Application Reference: 2026/0455.

Location: Avendale, 16 Station Road, Lundwood, Barnsley, S71 5LD.

This application seeks planning permission for the part-removal of an existing single storey extension to the rear, the erection of a two-storey rear extension with a Juliet balcony, and a loft conversion to form additional living accommodation with a re-roof and an increase in ridge height.

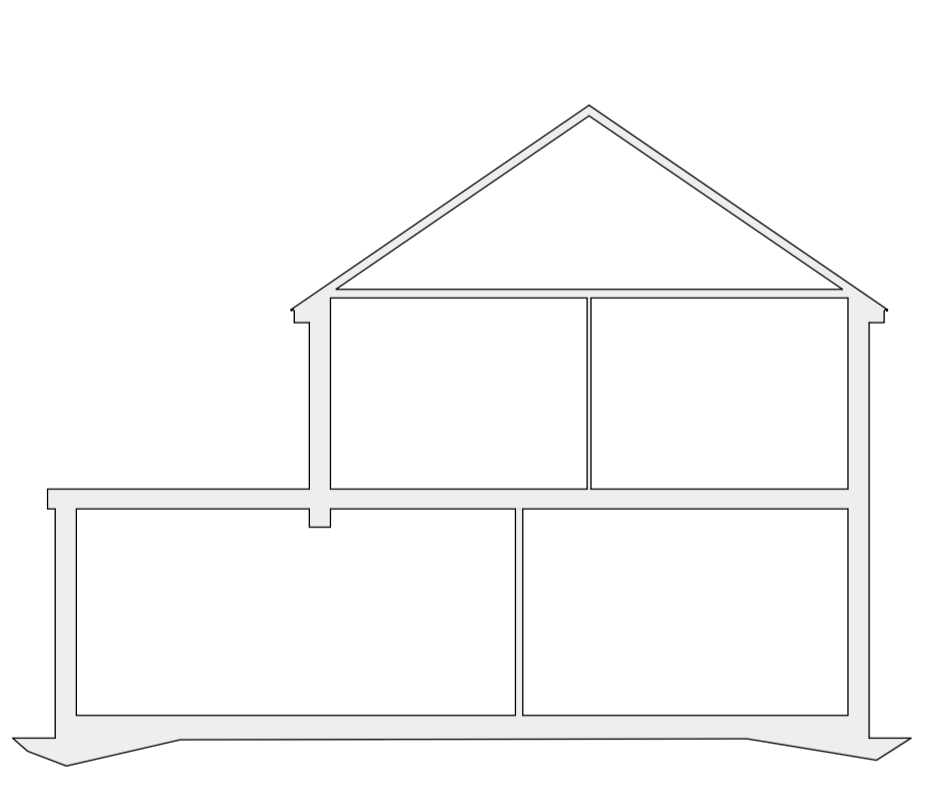
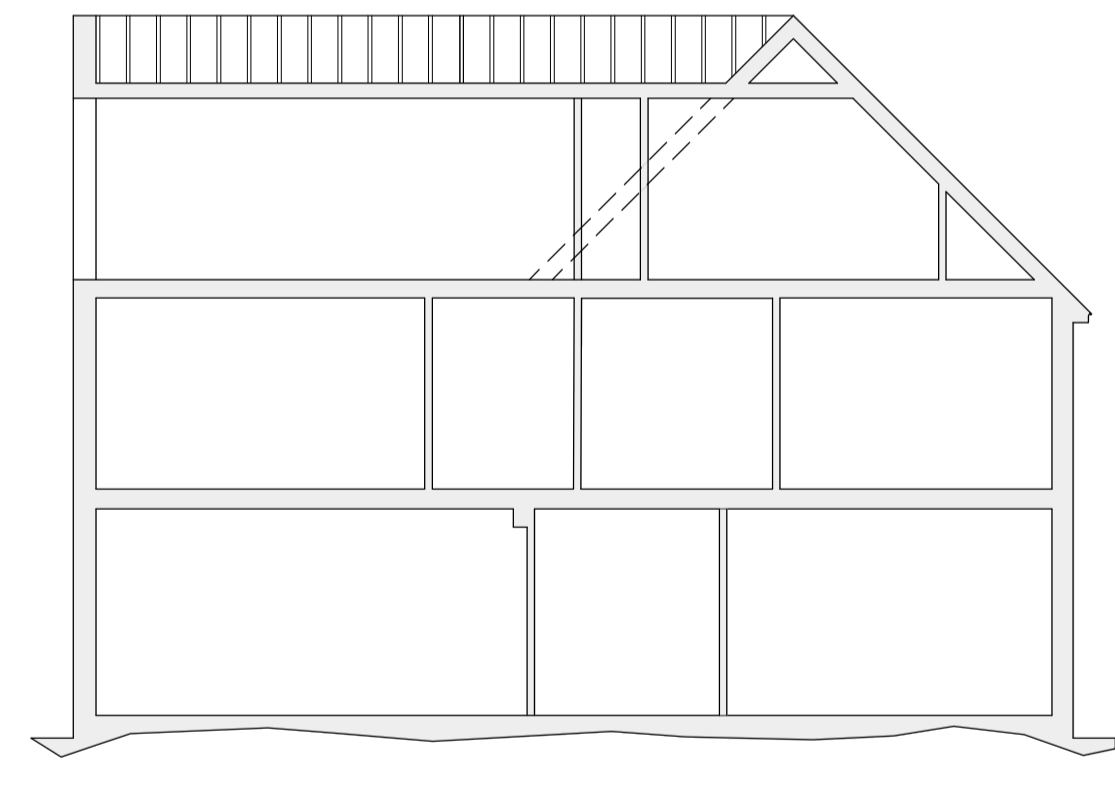
This proposal would increase the roof ridge height of the application dwellinghouse by approximately one metre. It is acknowledged that the application dwellinghouse benefits from a greater ridge height (as exists) compared with adjacent neighbouring properties and that other detached dwellinghouses in the building line also benefit from greater ridge heights. However, even with their greater roof ridge heights, these properties manage to appear proportionate and not overtly dominant or visually jarring within the context of the character of the street scene.

The proposed increased roof ridge height could give rise to an increased dominance and prominence within the ridge line and street scene. The proposed increased height would not be insignificant and could lead to a more abrupt step-up that could be seen as a more discordant break against the ridge line and horizon. The application dwellinghouse is set forward in the building line and could therefore, draw further emphasis to the proposed increased ridge height.

Nonetheless, this proposal would maintain the existing eaves height of the application dwellinghouse that would follow the continuous datum of adjacent properties, preventing abrupt visual breaks, and establishing a strong, unbroken visual horizon that grounds the street scene. Moreover, the massing, style and type of the proposed roof would likely generally appear proportionate and sympathetic and would enable the application dwellinghouse to respect the established local height hierarchy whilst also avoiding appearing incongruous within the context of the character of the street scene and local area.

Considering the above, whilst the proposed increased ridge height could introduce limited moderate harm to the character of the street scene of Station Road because of an increased vertical emphasis and a more abrupt step-up that could be observed as a more discordant break against the ridge line and horizon, this proposal would maintain the existing eaves height of the application dwellinghouse which would retain a strong, unbroken visual horizon that grounds the street scene of Station Road. The massing, style and type of the proposed roof would also appear proportionate and sympathetic and would enable the established local height hierarchy to be respected whilst avoiding appearing incongruous. On balance, this element of this proposal is therefore considered acceptable.

PROPOSED REAR ELEVATION PROPOSED SIDE ELEVATION PROPOSED FRONT ELEVATION PROPOSED SIDE ELEVATION

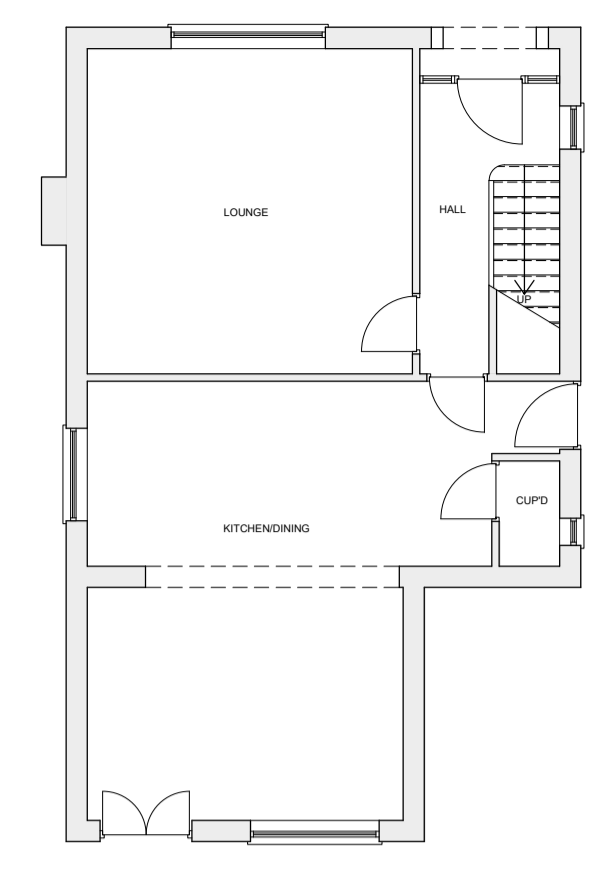
The proposed two-storey rear extension would adopt a sympathetic form and features comprising a moderate scale, a gable pitched roof, and the adoption of materials which would closely match those used in the external construction of the existing dwellinghouse. The proposed extension would also not be a prominent or dominant feature within the street scene and would not be readily visible from the surrounding public realm.

It is acknowledged that the proposed two-storey rear extension – which is sizeable – could contribute to some additional overshadowing because of its height and rearward projection. However, potential

It is acknowledged that the proposed two-storey rear extension – which is sizeable – could contribute to some additional overshadowing because of its height and rearward projection. However, potential overshadowing impacts affecting 18 Station Road would likely occur into the evening and not at peak times for use of a rear garden. Moreover, the proposed extension would not project beyond the rear elevation of the main part of this neighbouring property and therefore, it is anticipated that any potential overshadowing impact would likely be limited to its blank south-west side elevation. In addition, this proposal would maintain an existing separation distance to the shared boundary which would further lessen the extent of any potential impact. As such, it is not considered this proposal would contribute to significant overshadowing or loss of light and is considered acceptable in this regard.

The proposed first-floor windows and second floor Juliet balcony located on the rear elevation of the proposed extension would face into the development site and toward 14A Station Road beyond. The proposal would achieve an acceptable separation distance (21 metres or more) to the rear boundary of the development site and the adjacent residential properties beyond, in accordance with adopted design guidance. Two new first-floor windows are proposed on the south-west side elevation of the existing dwellinghouse and proposed extension to service a bathroom and en-suite. These windows are proposed to be obscure glazed despite serving non-habitable rooms and facing toward the blank north-east side elevation of 14 Station Road. Obscure glazing could be secured by condition for the avoidance of doubt. Therefore, it is not considered this proposal would contribute to significant overlooking or loss of privacy and is considered acceptable in this regard.

4. The proposed windows located on the south-west side elevation of the existing dwellinghouse, and the proposed extension, shall always be obscure glazed and retained thereafter.
